From: [REDACTED]
Sent: 10 November 2025 14:08
To: Planning
Cc: [REDACTED]
Subject: Objection to Planning Application No: 3/2025/0736
Attachments: No 25 Objection letter.docx

Planning Application No: 3/2025/0736

Proposal: Regularisation of detached garden room.

Location: 25 Middle Lodge Road Barrow BB7 9XS

Client: Sarah McMillan		
Project: Proposed Alterations 25 Middle Lodge Road Barrow		
Dwg title: Rear Garden Cross Section		
Scale @ A4: 1:50	Date: 07.03.25	Drawn by: PD
Drawing no. 1474 - 201		Rev. C

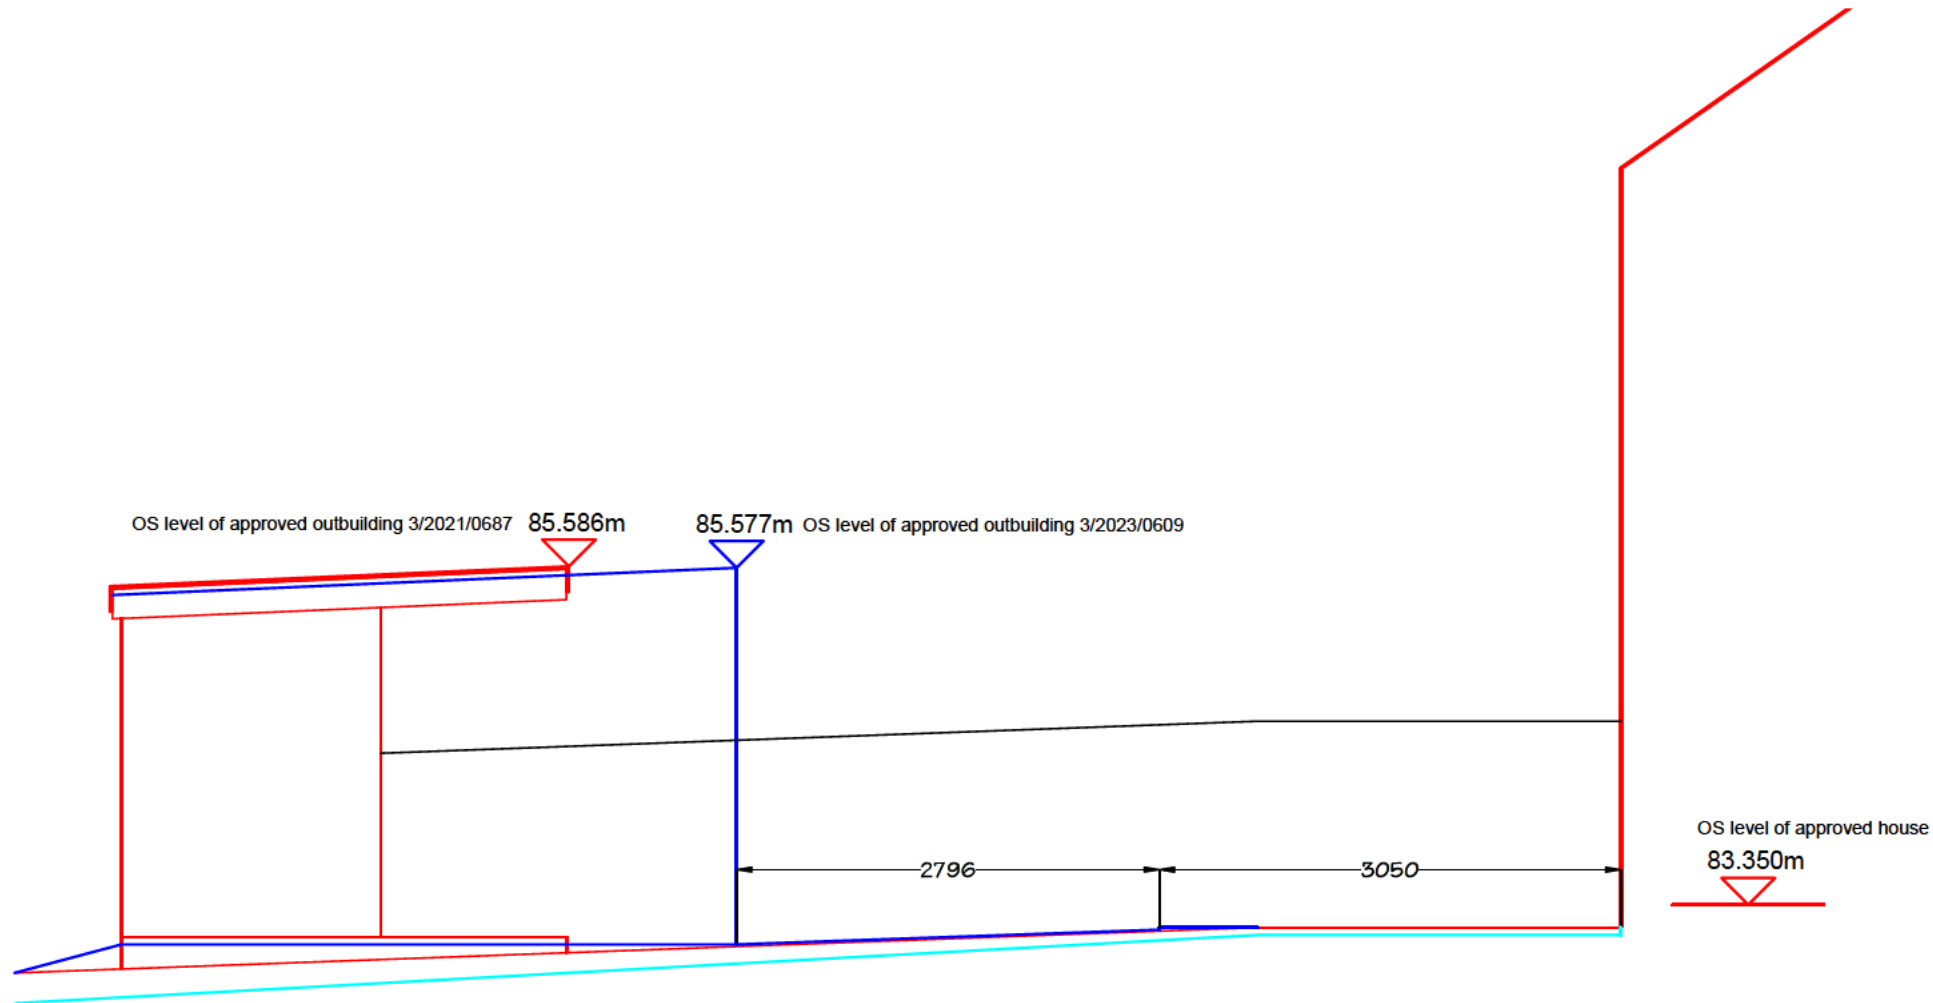
I am writing to formally raise my objection regarding unauthorised development works carried out at 25 Middle Lodge Road. These works include a significant raising of the garden ground level which was not part of the granted planning permission.

The raised ground level and the scale of the outbuilding have resulted in several issues which are having a direct and detrimental impact on my property including:

The increase in ground level has elevated the neighbouring garden area to the extent that it [REDACTED]. This has resulted in a serious loss of privacy and amenity, as activities [REDACTED] property.

4. Overbearing Appearance and Visual Impact

The combined effect of the raised ground level and the height of the detached garden room creates an unduly dominant and overbearing structure. It is out of keeping with the scale, siting, and character of other development in the immediate area.

6. Drainage and Runoff Concerns:

The change in ground level may also affect surface water drainage, potentially increasing the risk of water runoff or flooding into neighbouring gardens, [REDACTED]

Client: Sarah McMillan		
Project: Proposed Alterations 25 Middle Lodge Road Barrow		
Dwg title: Proposed Elevations Garden Room		
Scale @ A4: 1:50	Date: 18.07.23	Drawn by: PD
Drawing no. 1474 - 08		Rev: B

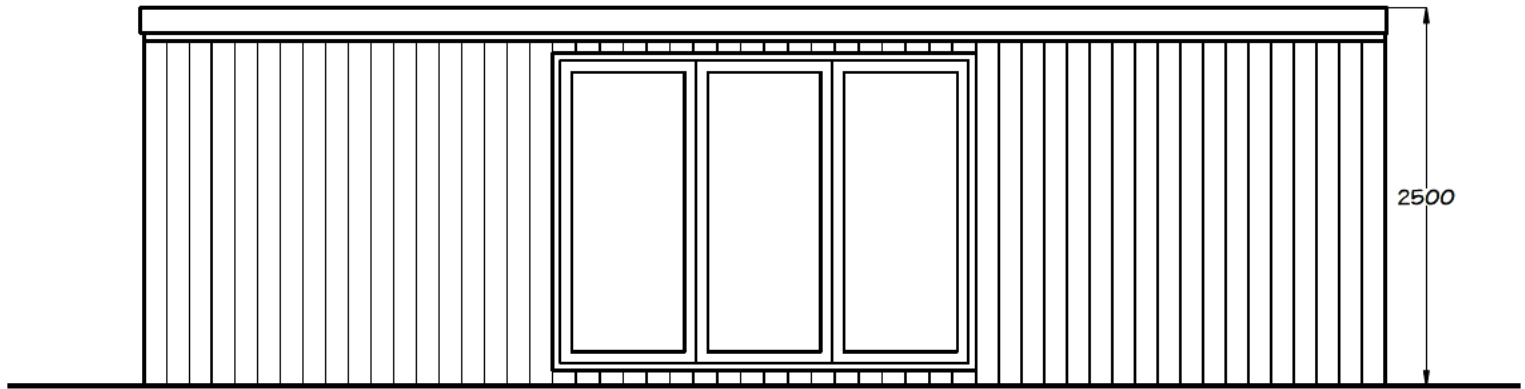
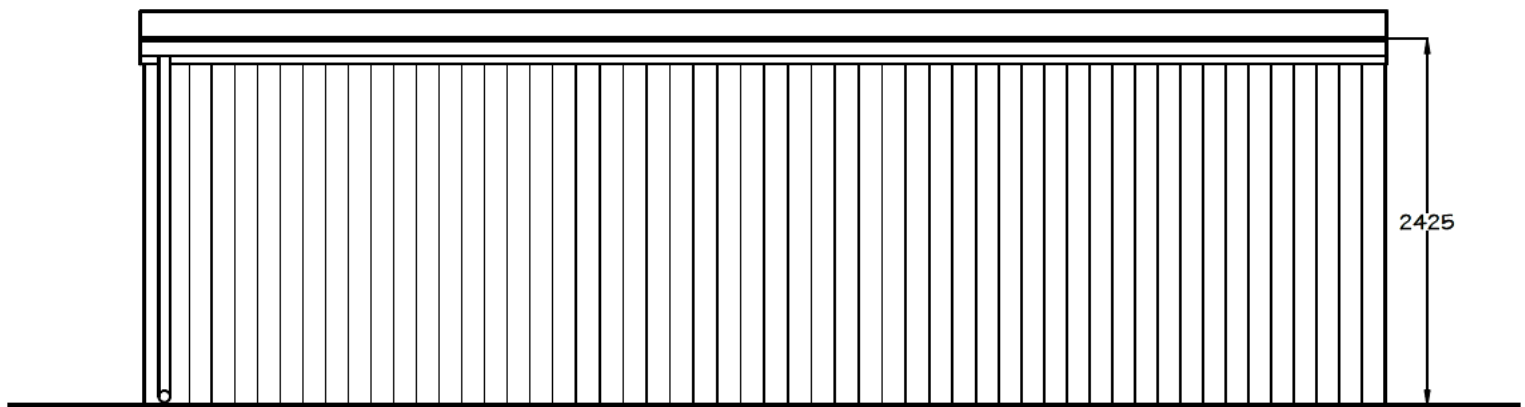
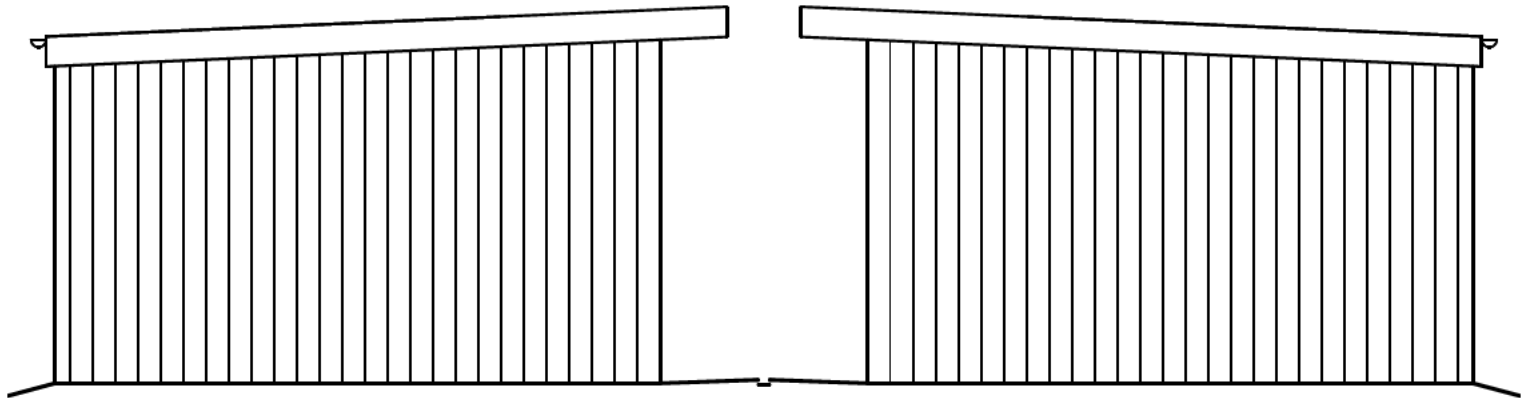
The detached garden room when in use generates both considerable noise and artificial lighting late into the evening. This causes unacceptable disturbance and negatively affects the peaceful enjoyment of [REDACTED]. The room has not been fitted with any kind of soundproofing and in fact, acts as giant boom box meaning that sound carries across the estate.
